Planning Applications: 3/2025/0360 & 3/2025/0361 (respectively)

Writtenstone Farm, Writtenstone Lane, Longridge

Re: Conditions 26 & 14 (archaeological building recording)

Plate 89 (left): North-east truss, Room F2 of the barn, viewed from the north

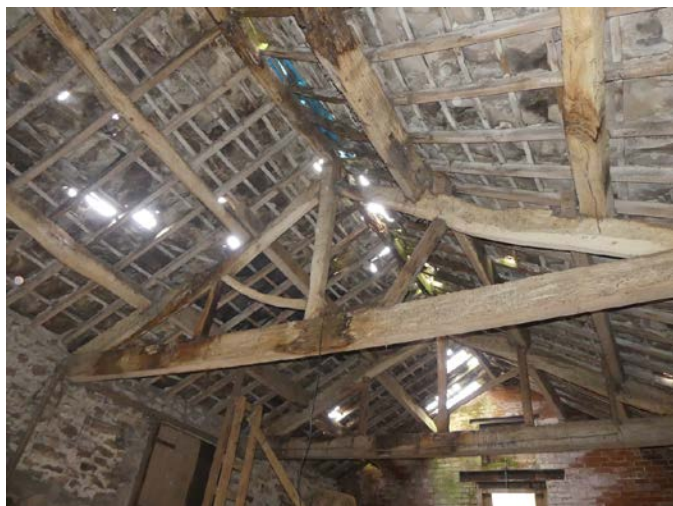
p.38, 4.4.7 – no mention is made of the cleats that can be seen on the trusses; only two of the four trusses are shown and the two that are illustrated they are not the same, the central truss has struts that do not fit into the king post as is the case with the north-east truss; the central truss would appear to be a later replacement, it having the appearance of being machine-cut.

Figure 6: Cross-section A-A1

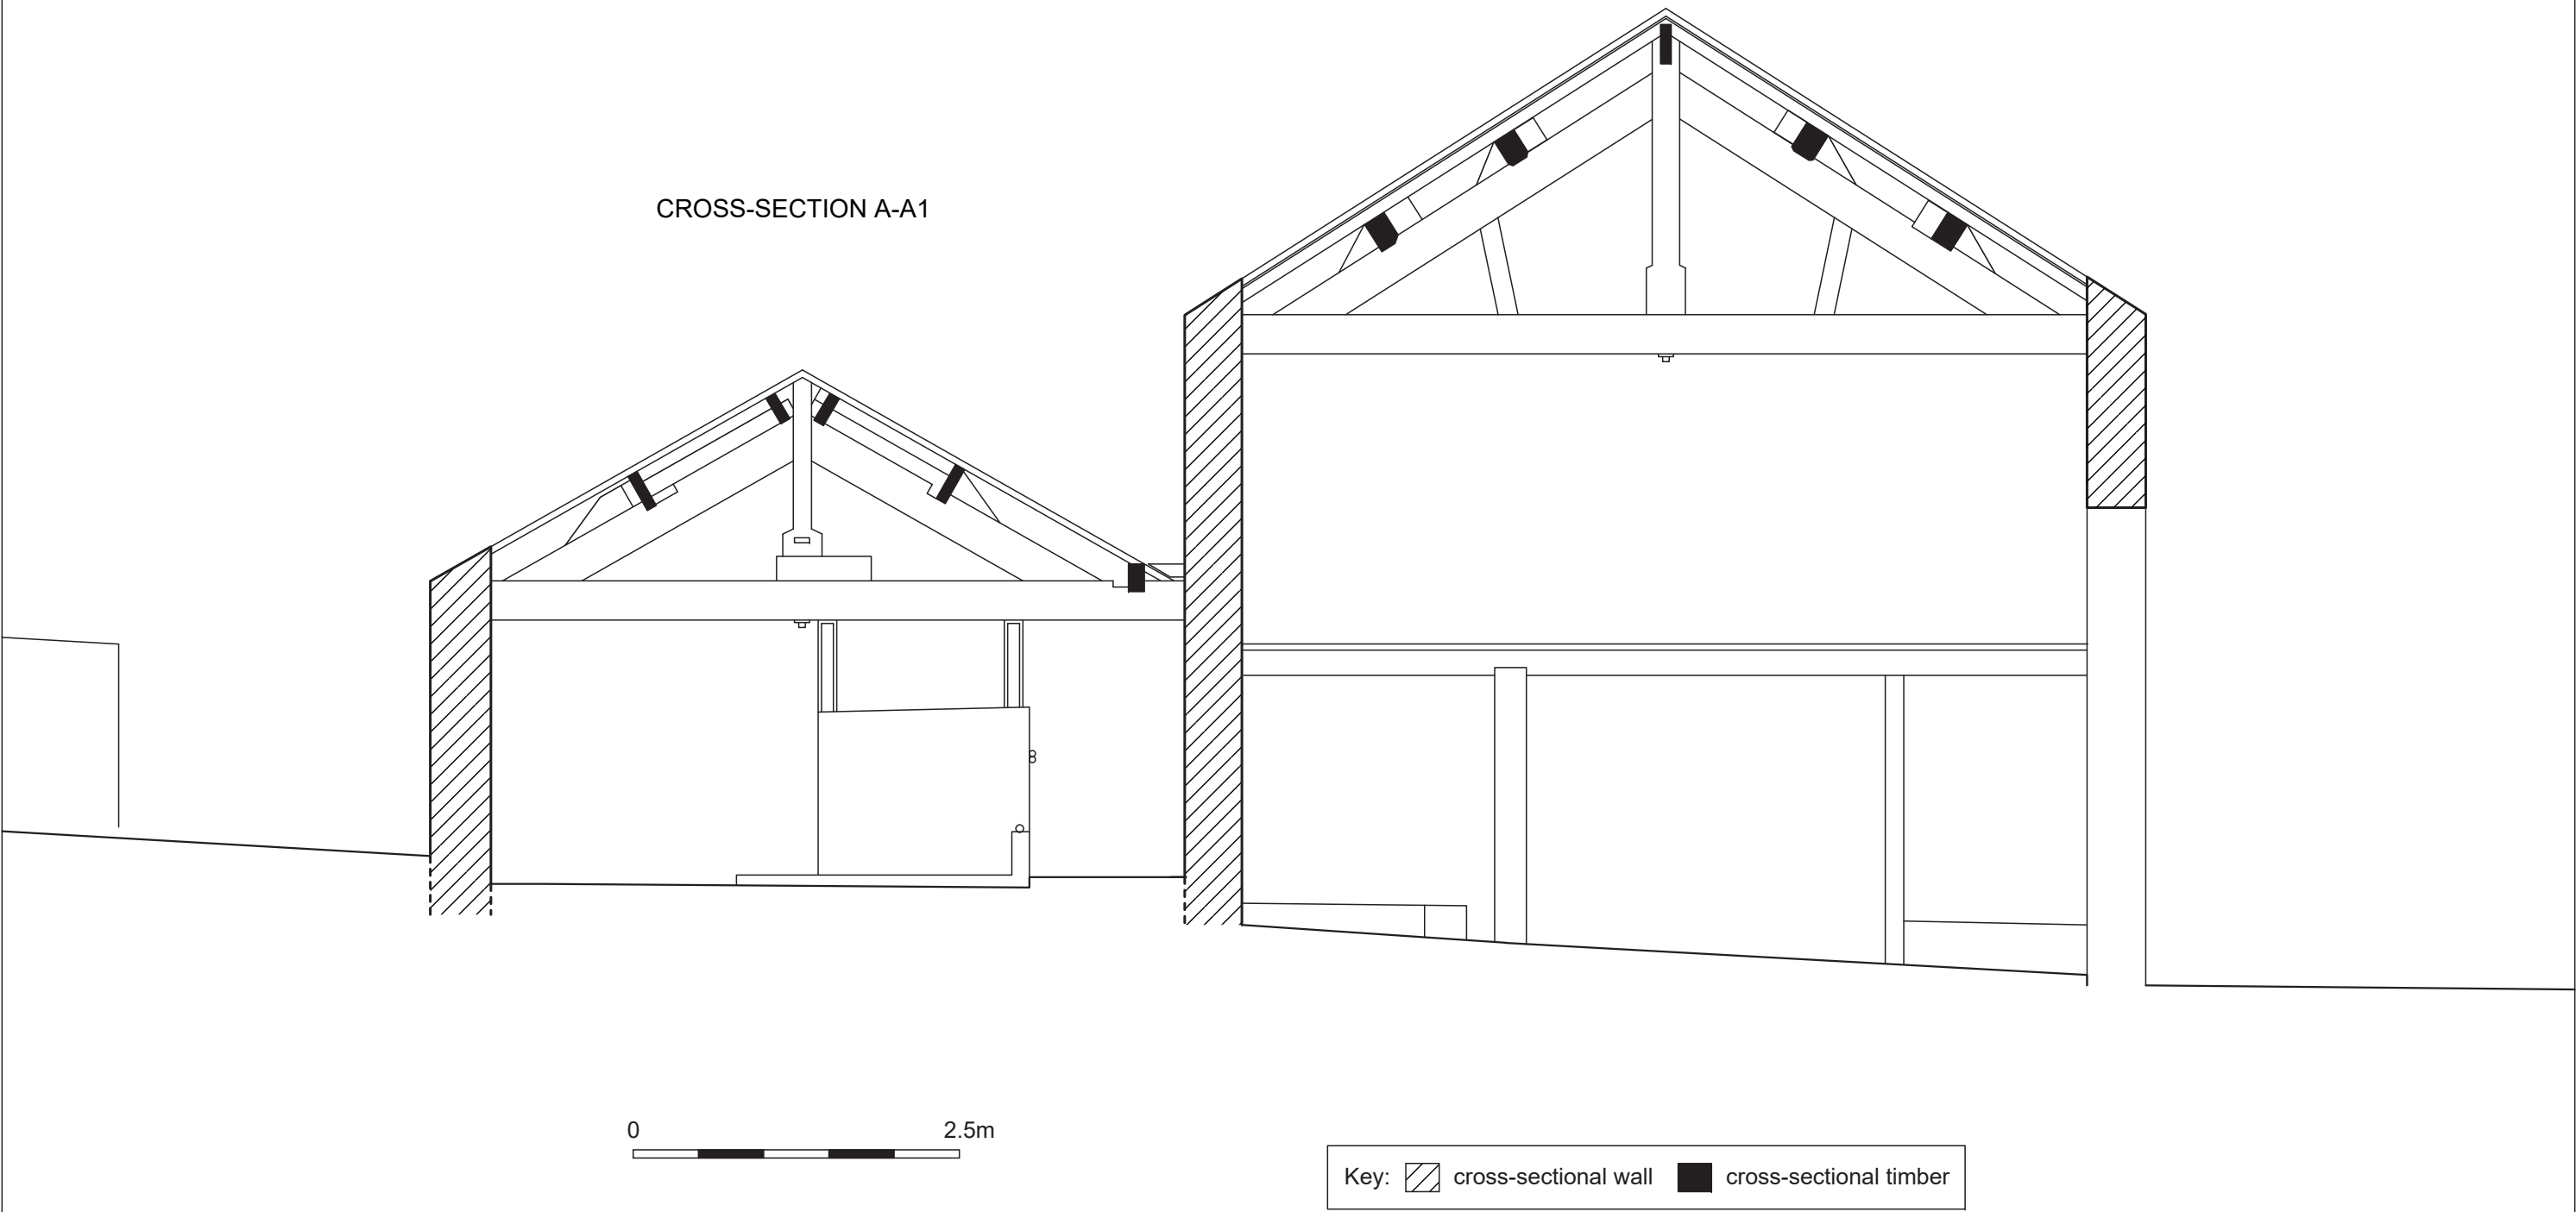
p.45, Figure 6: Cross-section A-A1 shows only one type of truss, the other type of truss should have also been drawn.

Figure 10: Phase plan showing the development of the barn

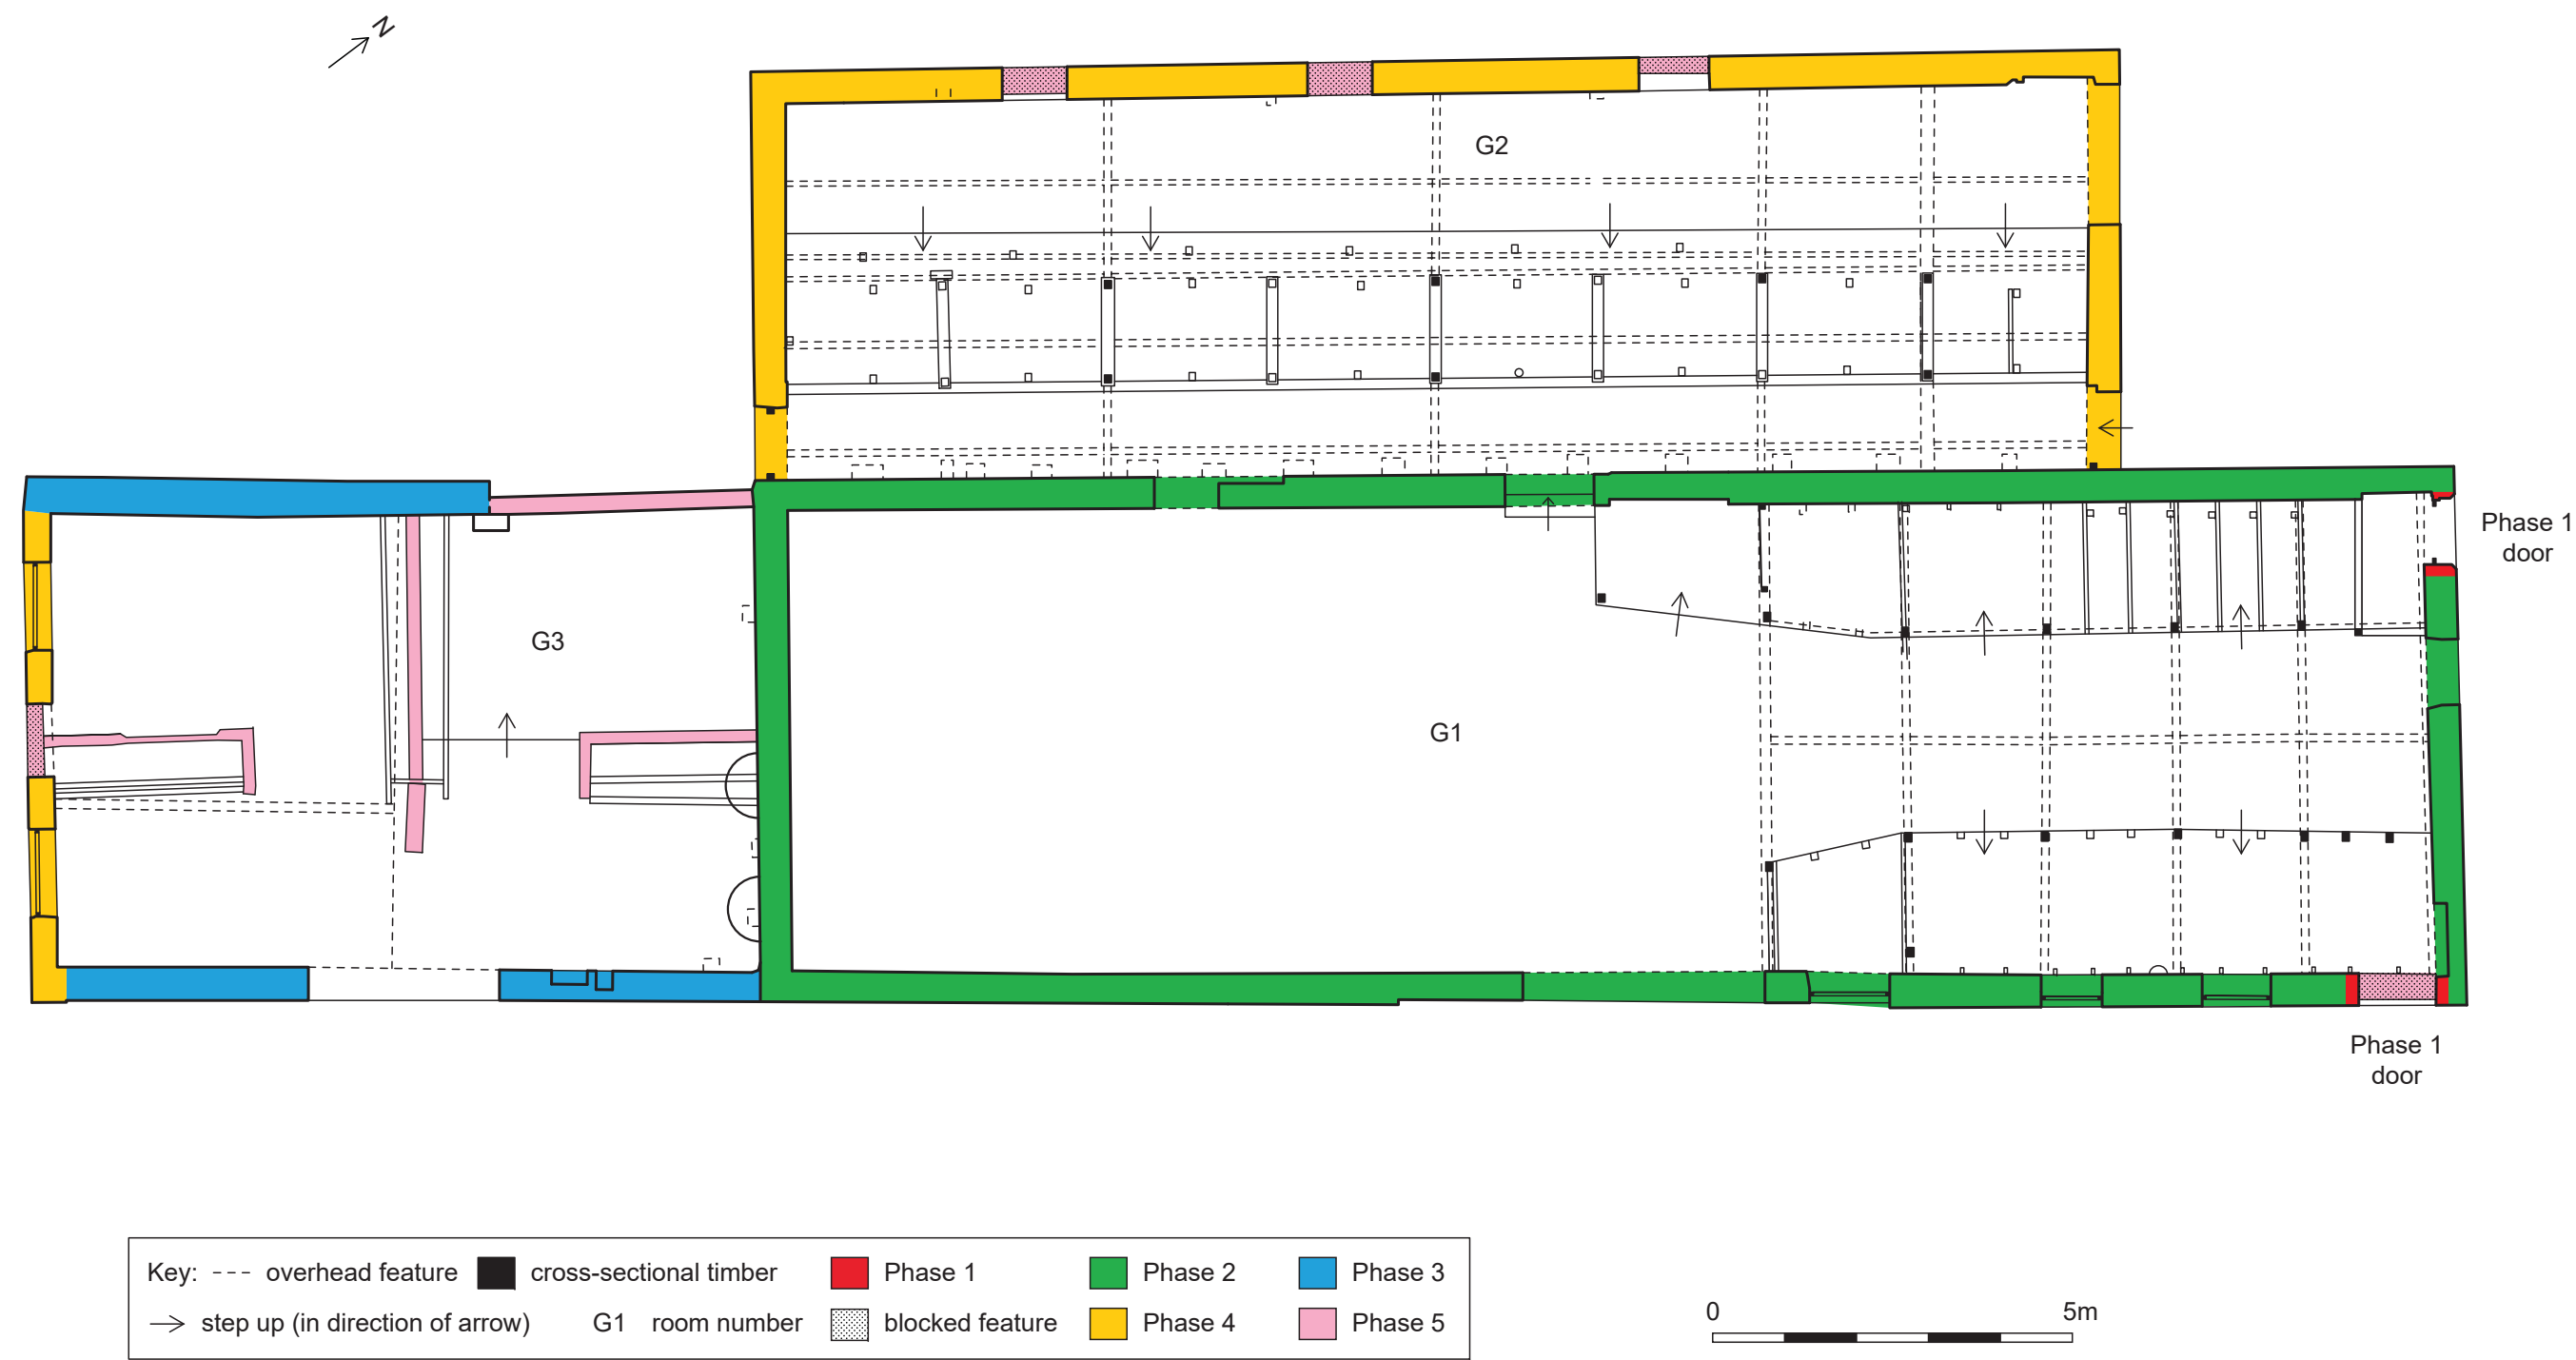
p.57, 5.2.1 – "have allowed *** phases...", should be "have allowed 5 phases...". This would be more easily understood in a coloured phase plan.
